Planning Application Ref: Y/91/17/OUT

Location: Land at Bilsham Road, Yapton

Description of works: Outline application for the development of up to 250 residential dwellings (Class C3) vehicular access, public open space, ancillary works and associated infrastructure. Departure from the Development Plan

Tree Officer / Parks and Greenspace Team

- Key.
- RPA for CAT A\* tree to be retained
  - RPA for CAT B\* tree to be retained
  - RPA for CAT C\* tree to be retained
  - RPA for CAT U\* tree to be retained
  - Canopy of tree to be retained
  - Canopy of CAT U\* tree to be removed

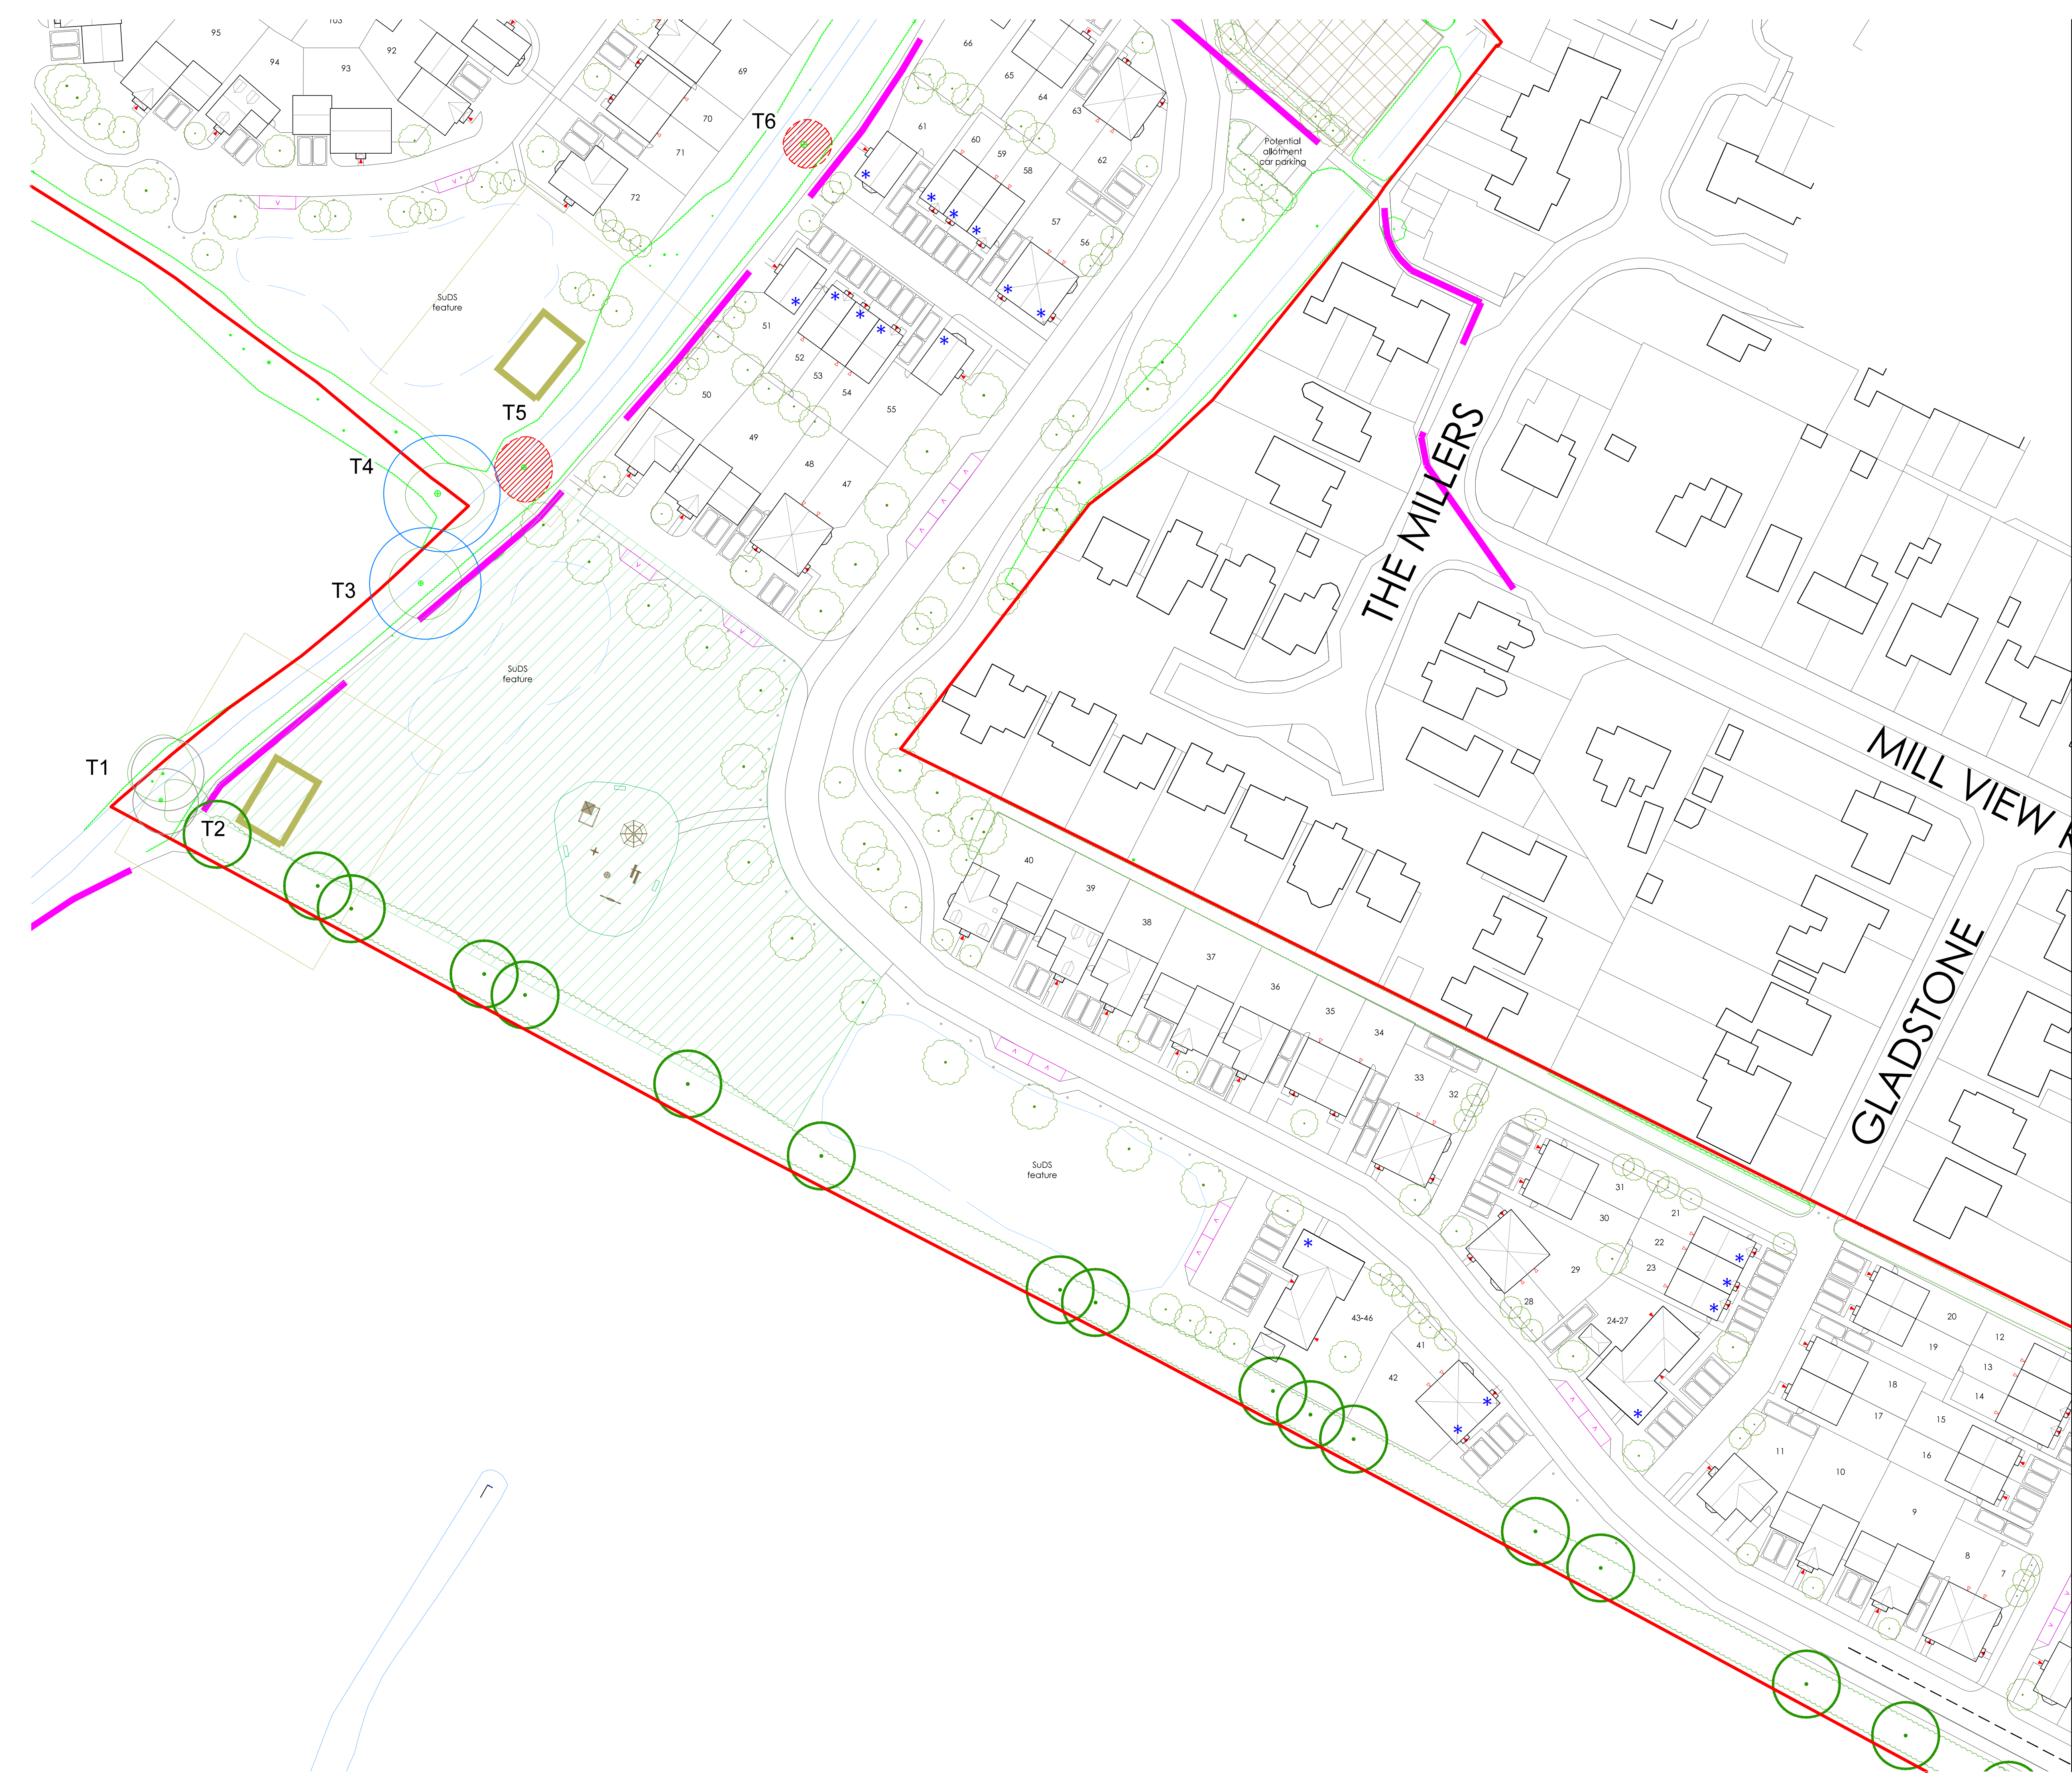
- The applicants employed the PJC Consultancy back in November 2017 to undertake a tree survey and then prepare an Arboricultural Impact Assessment (AIA) PJC/4699/17-02 R2. Tree Survey data is adequate at this stage and broadly accords with the requirements of BS5837:2012. I have referred to Illustrative detailed masterplan drg. 1244G.03 to assist with determining the accuracy of the Tree Constraints and Tree Retention Plans submitted by PJC with their AIA report. This allows me to gain a general understanding of how the plot layout and access routes relate to trees but is not specific enough for me to have full confidence they will be adequately respected and protected. PJC Consultancy have submitted a revised Arboricultural Survey and AIA, ref. nos 3867/15/01 & /02 - Rev 04 and dated 13th and 14th March 2018 respectively. I have been asked to consider the amendments and provide comment. The supporting text within suggests a well-intentioned plan for significant trees on the site although it lacks the necessary detail to ensure their adequate protection and respect once development is underway.

- I am pleased to see there is intent to retain the vast majority of recorded trees in harmony with the development, but I cannot be satisfied that this will be achievable until we receive a Tree Protection Plan (TPP) overlaying the final proposed site design layout, with supporting Arboricultural Method Statement (AMS) where RPA (Root protection area) incursion is anticipated - which I would expect to see submitted with a subsequent full planning application.

- At this outline stage, the indicative layout and access arrangements and the appointed arboriculturalist's general regard for significant trees existing on site are encouraging and I am in broad agreement with their survey information. That said, I am concerned that there appear to be notable omissions in respect of existing tree cover along several sections of the site perimeter (South, adjacent arable farmland – East, rear of The Millers – North, south of dwellings at Tack Lee Road). This may be deliberate as the proposed design does not at this stage suggest any direct interference with them but it is important to consider all trees whether they are on or off-site and within potential influencing distance, so as to inform the site layout design which may of course be subject to revision. Any omissions will need to be addressed and therefore included in the aforementioned TPP and AMS should this proceed to a full planning application. Despite appearing in symbolic form on the Illustrative detailed masterplan drg. 1244G.03, significant trees located within the Southern site perimeter hedgerow were omitted from the tree survey schedule provided by PJC. They are of such dimensions and proximity as to be a material consideration and will require full consideration and appropriate levels of protection before any work can commence on site. I have determined that the majority of these merit a TPO. These trees have now been included in the tree survey schedule and so should be recognised in the anticipated TPP.
